From: Ella Pope [REDACTED]
Sent: 11 May 2021 09:32
To: Kathryn Welch <Kathryn.Welch@arun.gov.uk>
Subject: RE: A/59/21/CLP 10 Lambert Way

From: [Kathryn Welch](#)
Sent: 11 May 2021 09:29
To: [REDACTED]
Subject: A/59/21/CLP 10 Lambert Way

I note in your description within the submitted planning statement that for the roof dormer you have both described the materials 'to be sympathetic' to the existing and to be 'of a similar appearance'. In order to comply

PROPOSED LOFT
CONVERSION

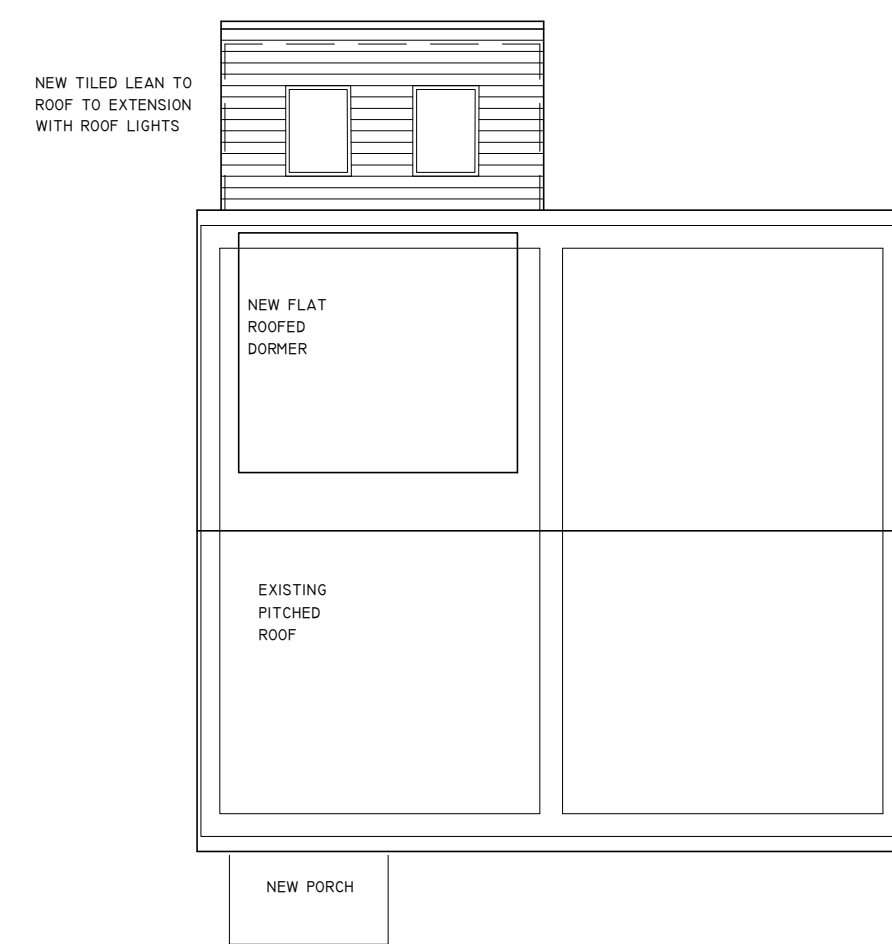
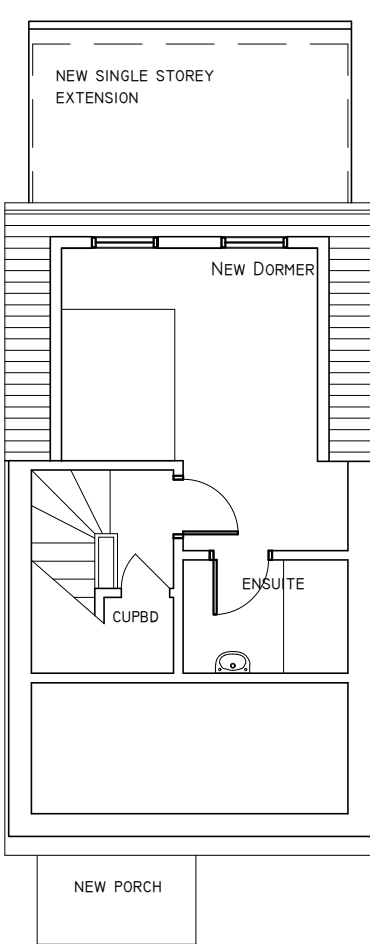
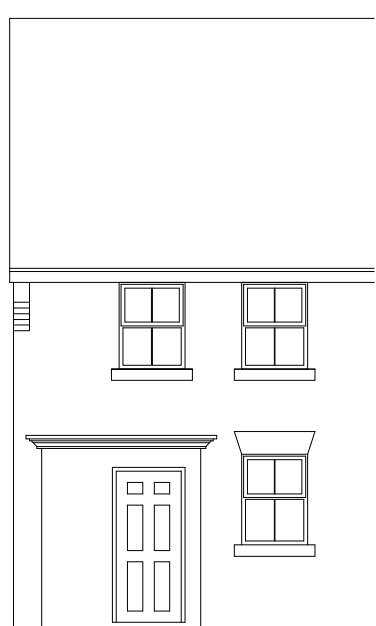
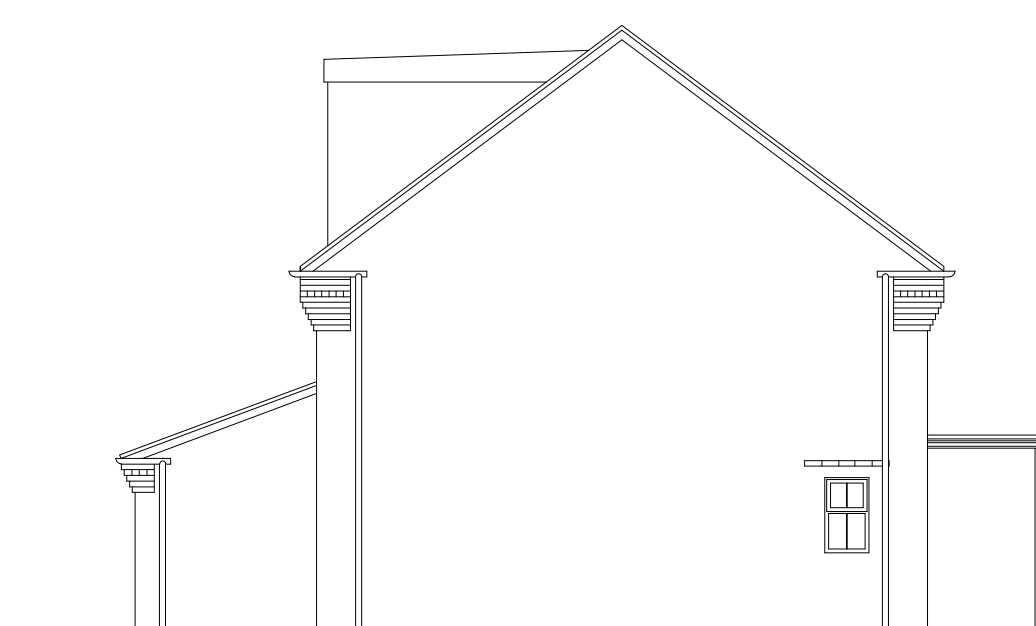
with condition B.2 (a) of the GPDO the latter is required. So for the avoidance of doubt could you confirm that the materials will be of similar appearance to those use in the construction of the existing dwelling house.

Thank you for coming back to me, and with regard to the wording I can confirm that the materials to be used for the proposed dormer will be 'of a similar appearance' to the those used in the construction of the existing dwelling house.
